Application Ref:	2025/0305				Ribble Valley Borough Council www.ribblevalley.gov.uk		
Date Inspected:	Various.	Site Notice:		23/05/2025			
Officer:	EP						
DELEGATED ITEM FILE REPORT:				REFUSED

Development Description:	Regularisation of landscaping and engineering works to create extended parking area to front and terracing at the rear and new summer house to rear.
Site Address/Location:	36 Painter Wood, Whalley Old Road, Billington BB7 9JD.

drawing title:  
PROPOSED SITE PLAN

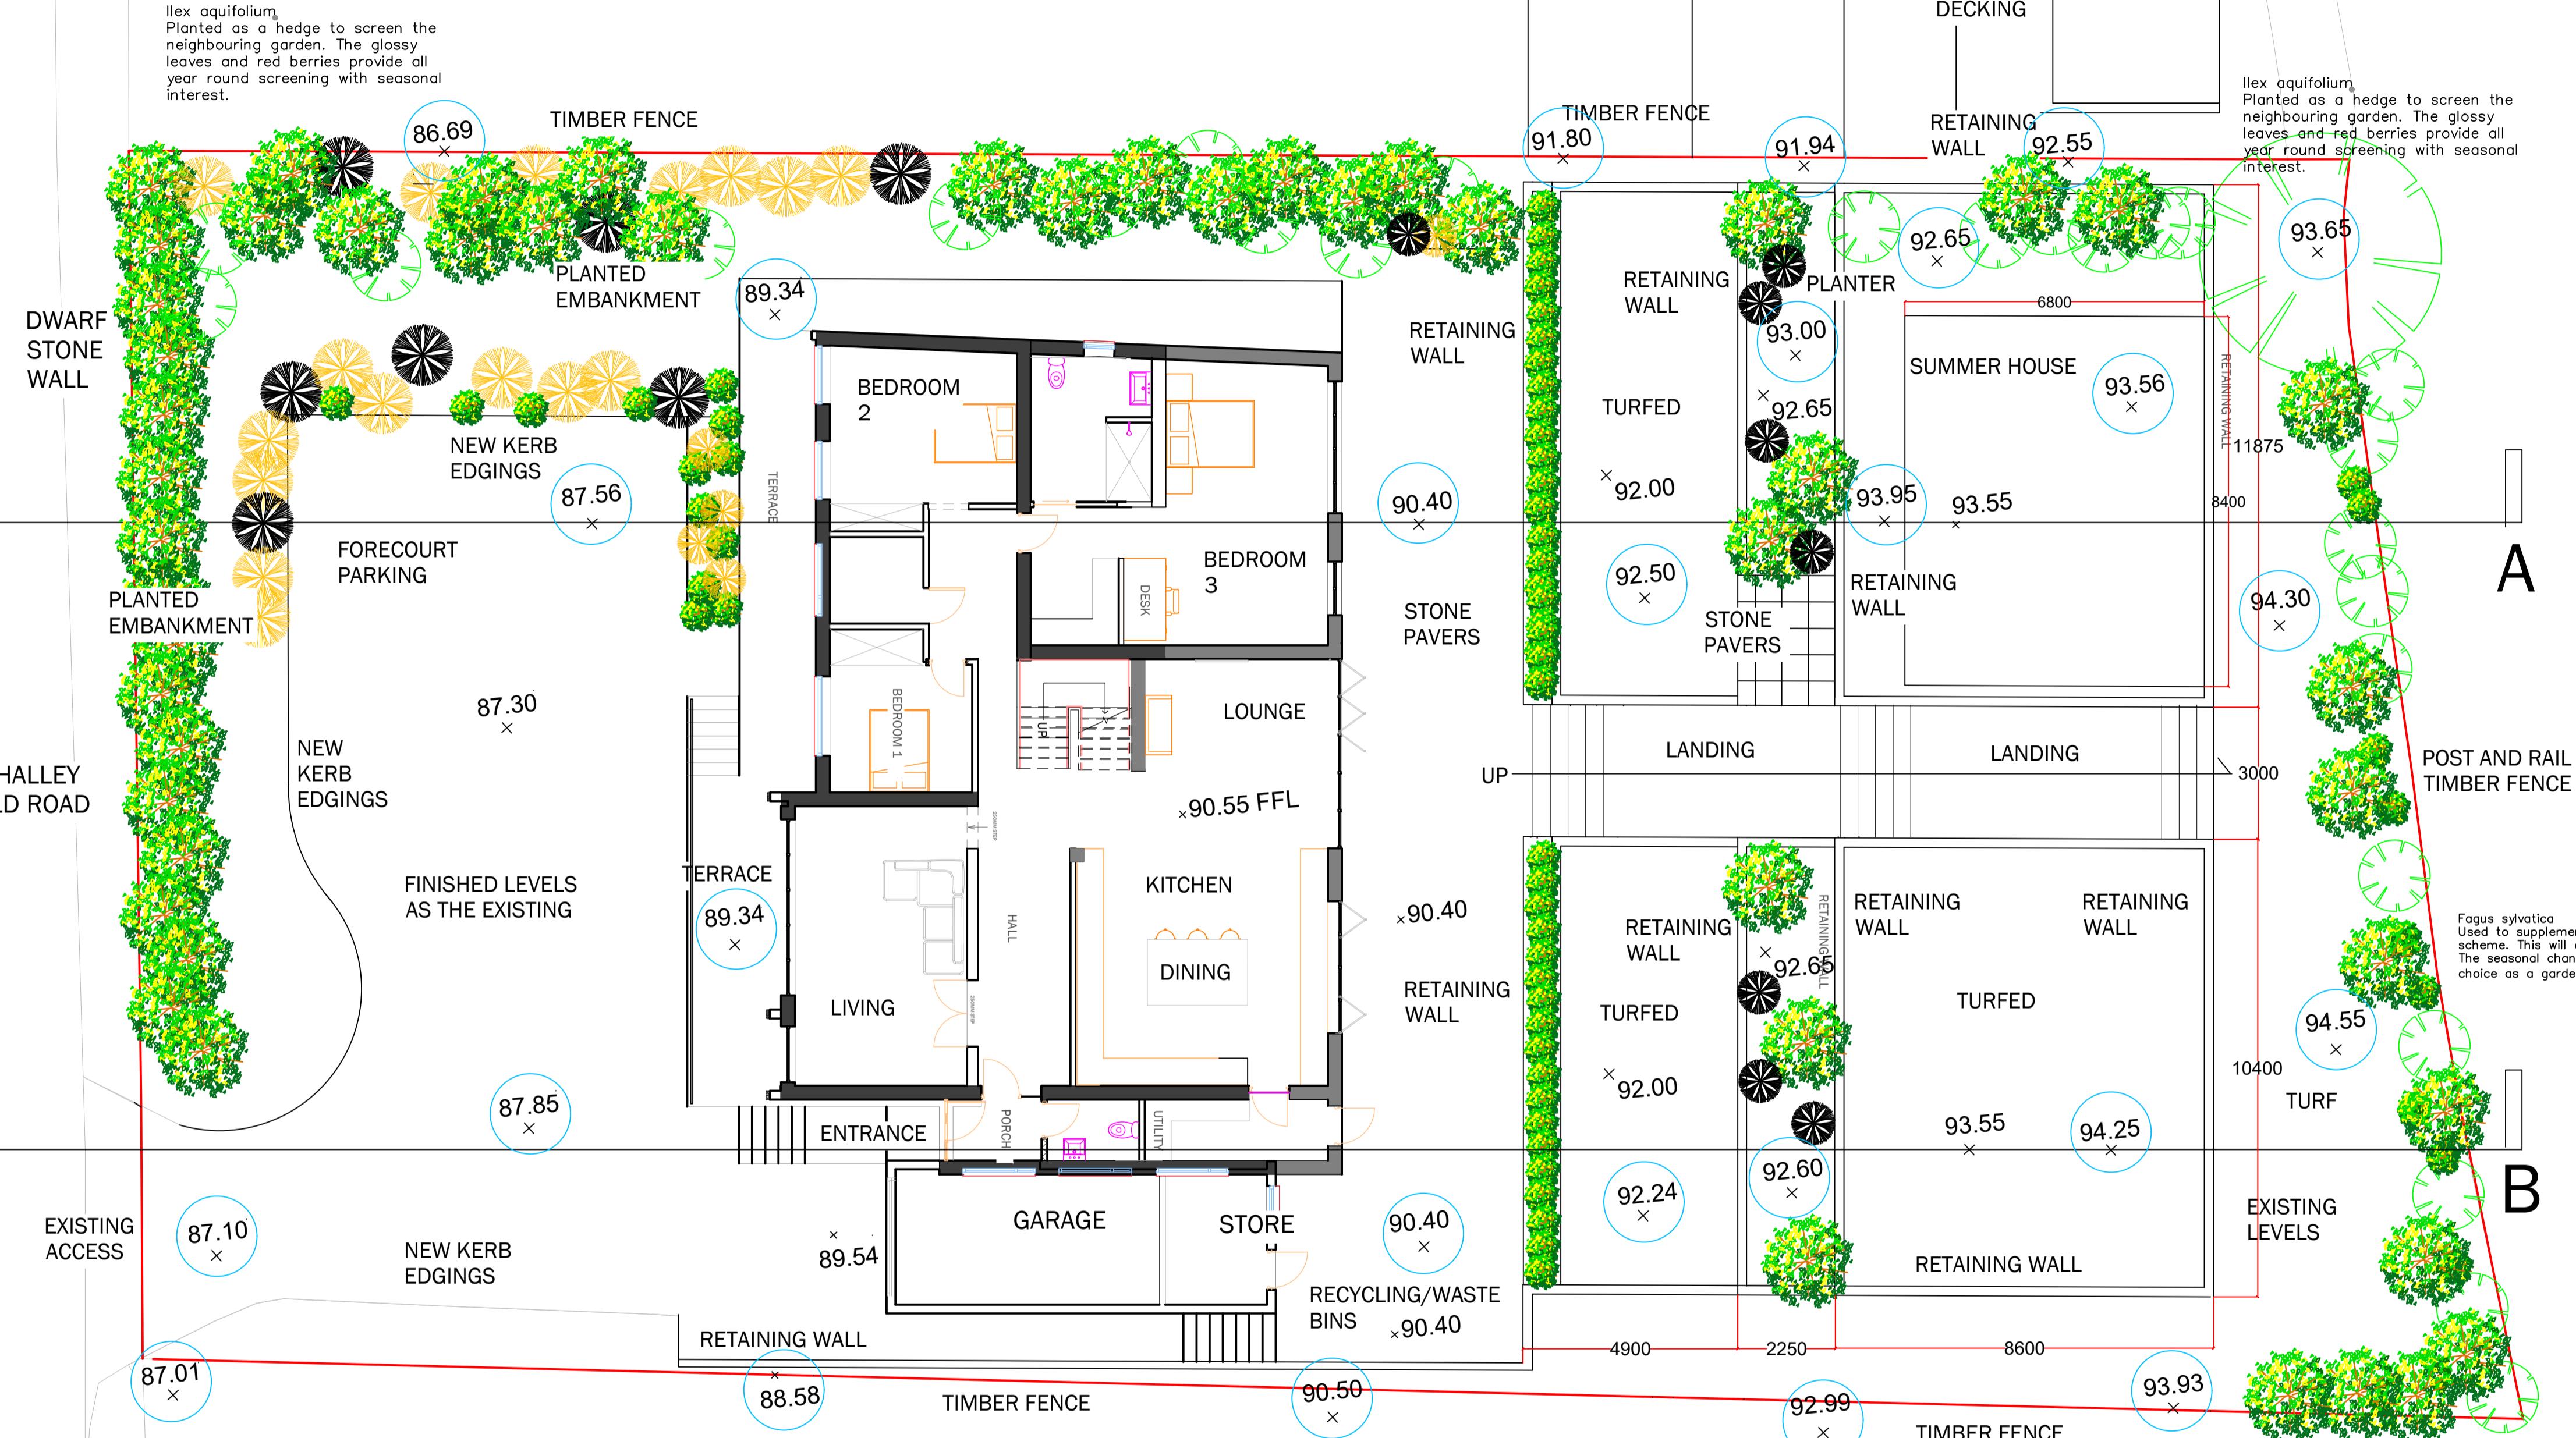
The proposed terracing in the rear of the site would result in the introduction of a number of stone retaining walls. Given the significant amount of such walls proposed, and subsequent increase in solid built form, the existing open character of the curtilage will be lost. This is particularly harmful given the open nature of neighbouring curtilage and landscape surrounding the development site, in stark contrast with the proposed development. It is recognised that landscaping is proposed in an effort screen and soften the proposed retaining walls. But given the substantial change in land levels from the dwelling itself to the rear edge of the curtilage (approx. 4 metre height increase) the supporting retaining walls have substantial height and visual prominence that cannot be suitably mitigated by the landscaping proposed. The original garden was almost entirely laid to lawn. Whilst some areas of the proposed scheme are to be turfed, the retaining walls will likely entirely screen these elements, resulting in the previously open and undeveloped curtilage being lost and becoming overdeveloped to an unacceptable degree.

It is therefore not considered that the proposed development is appropriate in its context, by virtue of an overdeveloped rear curtilage, substantial increase in built form and loss of openness. Contrary to Policy DMG1 and of further harm to the openness of the defined greenbelt.

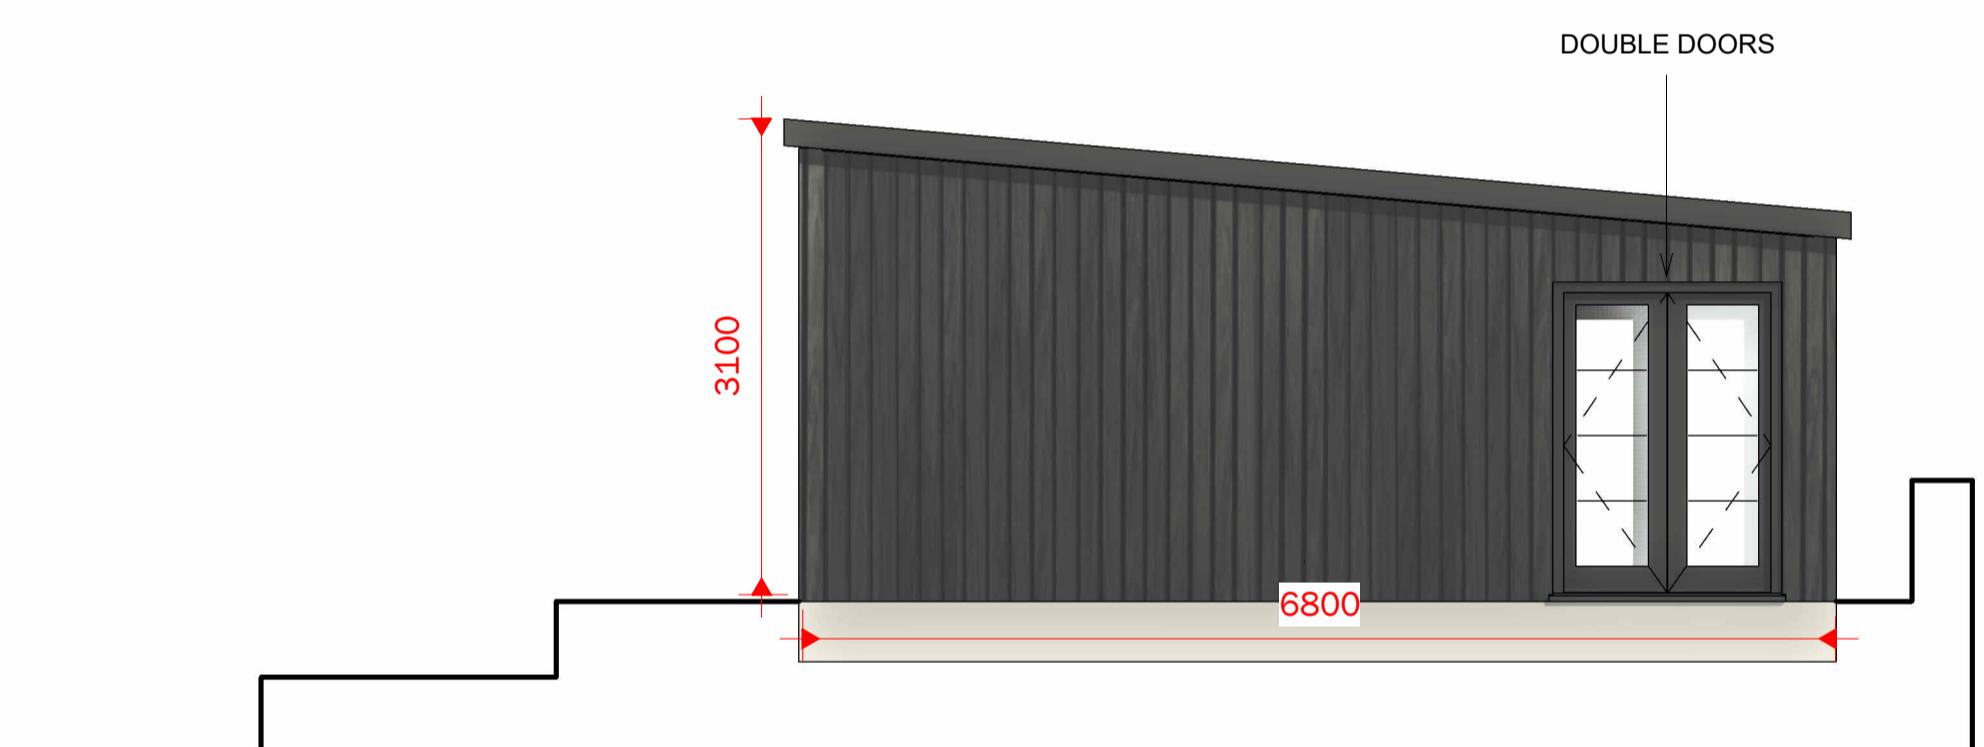
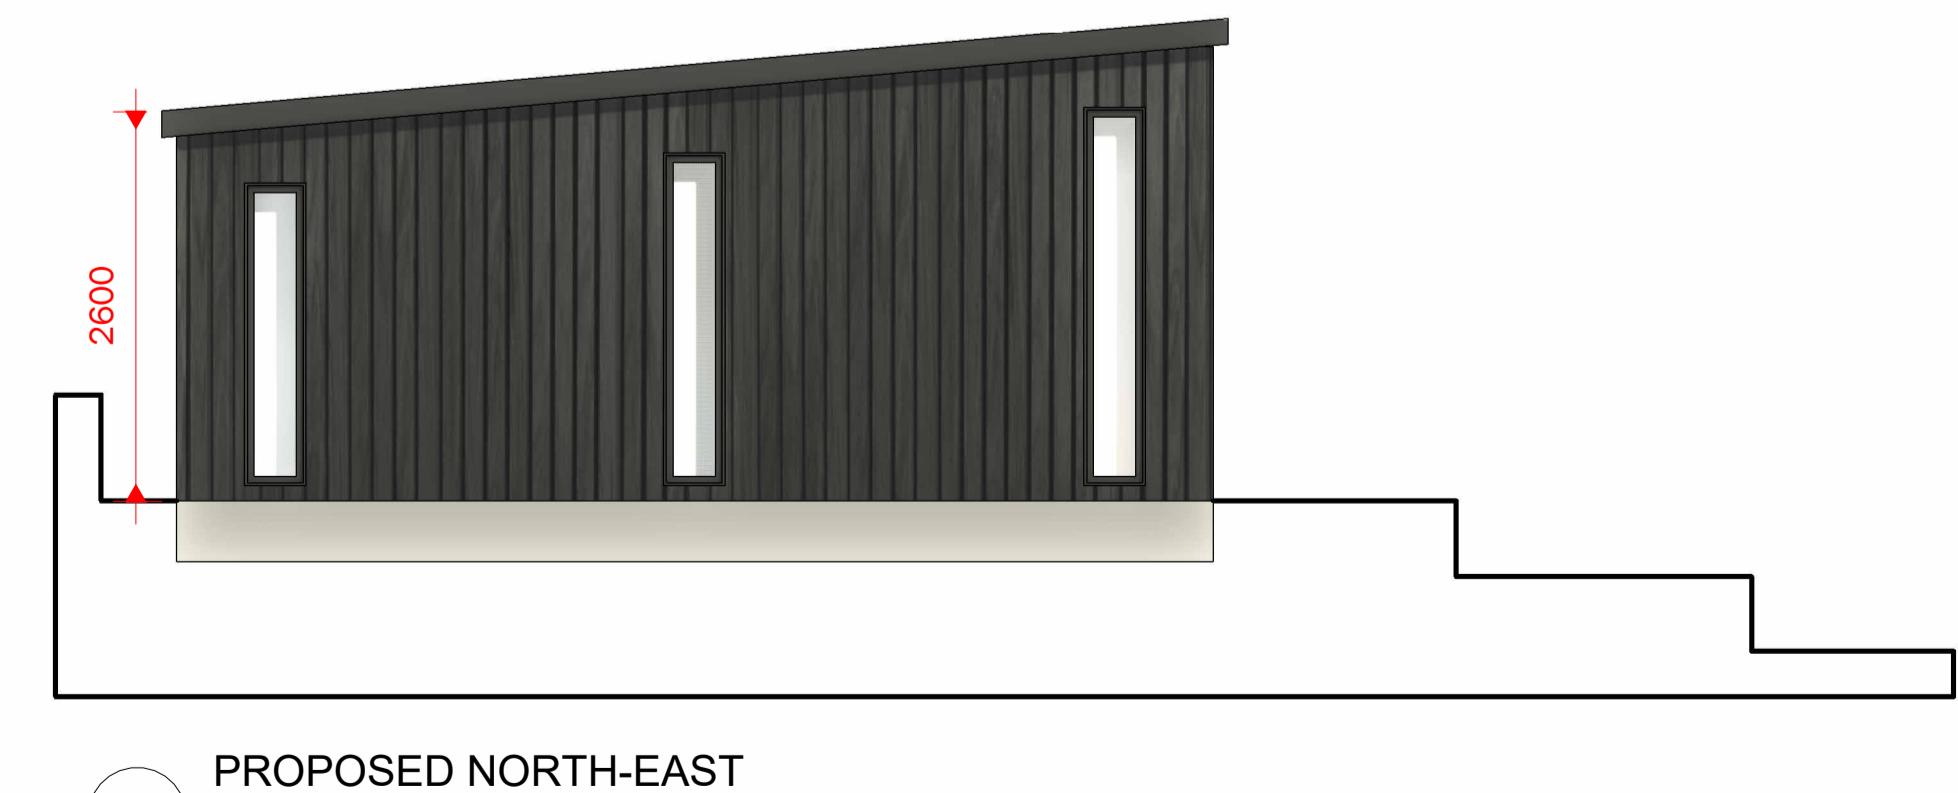
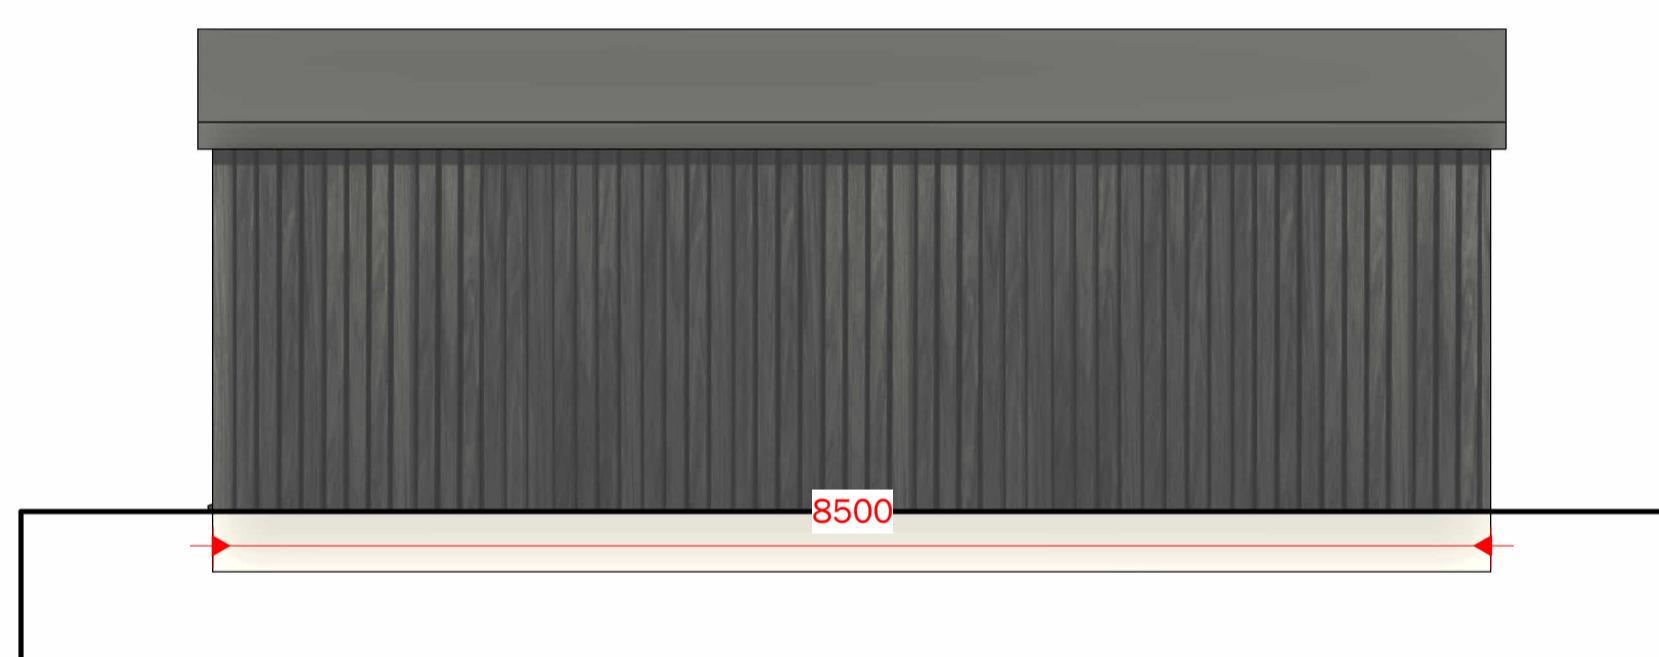
The proposed garden building is substantial in size, measuring 6.8m by 8.4m with a maximum height of 3.1m. When compared against the existing dwelling, the footprint of the proposed building is substantial. The footprint is even greater when compared with the footprint of the original dwelling. As such, it is considered that the proposed summer house would be an unacceptable addition within the greenbelt by virtue of its excessive scale in relation to the host dwelling. The proposed building is to be sited in the most easterly section of the rear curtilage, away from existing built form. Further enhancing its prominence within the defined greenbelt, particularly given the rear curtilage abuts undeveloped landscape.

The proposed garden room is located to the eastern edge of the curtilage with large sections of glazing proposed. The original scheme featured glazing on the southwestern side elevation of the building, however this has since been removed by the applicant in the interest of protecting the amenity of the neighbouring receptors to the southwest. There is still glazing proposed on the principal elevation of the building which would likely afford some levels of overlooking into neighbouring curtilage. However, given it is possible to overlook neighbouring curtilage within the existing garden due to sloping topography, it is not considered this forms basis for refusal. In addition, obscure glazing could be secured via planning condition.
